**From:** Brenda Larsen  
**Sent:** Tuesday, November 26, 2013 11:29 AM  
**To:** Jeff Watson  
**Subject:** Brain SP13-00010

Re: Brain Short Plat SP-13-00010

BRAIN SHORT PLAT
PART OF SECTION 36, T. 18 N., R. 18 E., W.M.
KITTITAS COUNTY, WASHINGTON

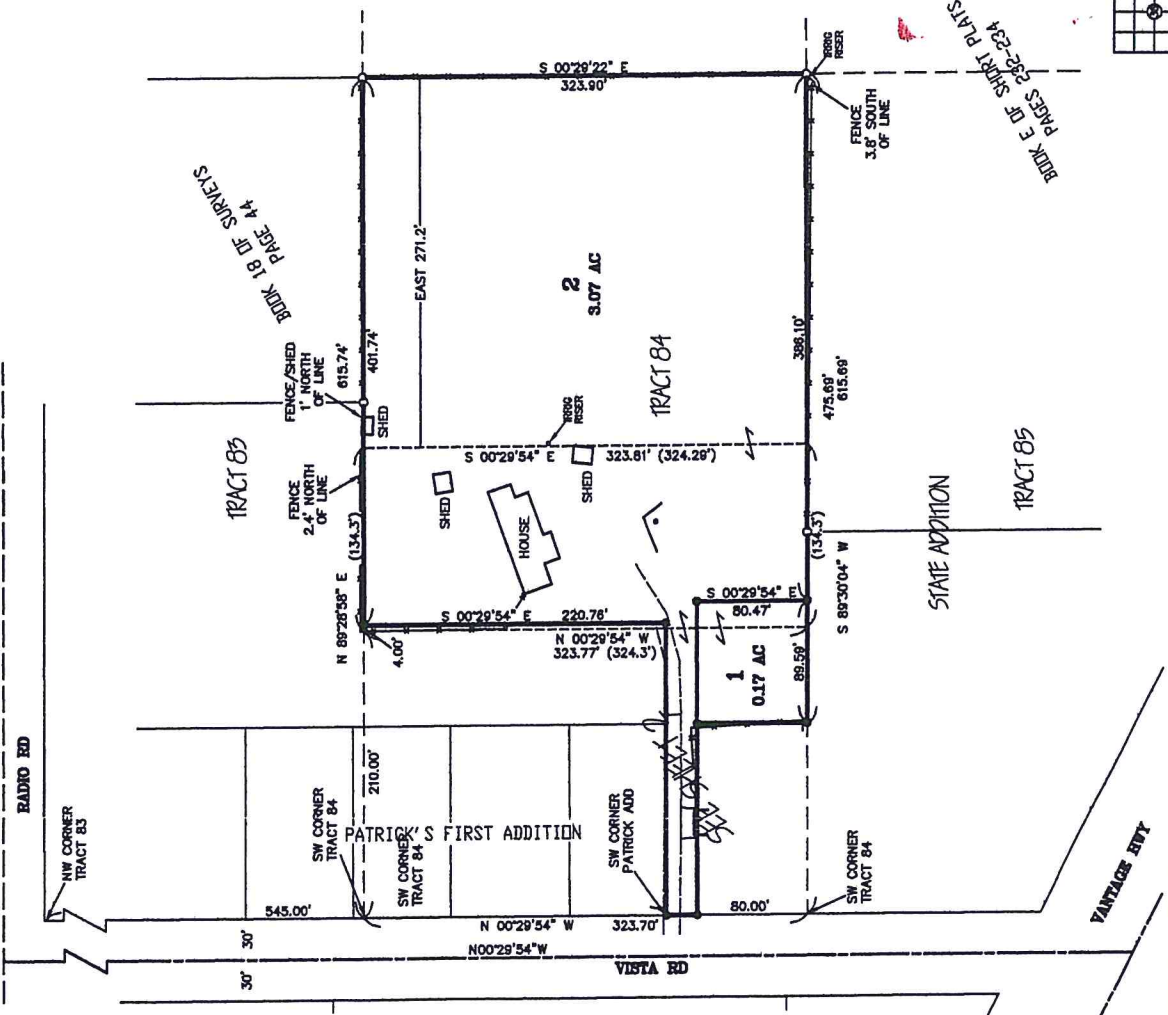
- The driveway(s) for the new property must comply with Kittitas County Code, i.e. any driveway greater in length than 150' shall be no less than 16 feet in width.
- The addresses shall be posted at the front of the property and easily visible from the road to emergency responders.
- All future development must comply with the International Fire Code.
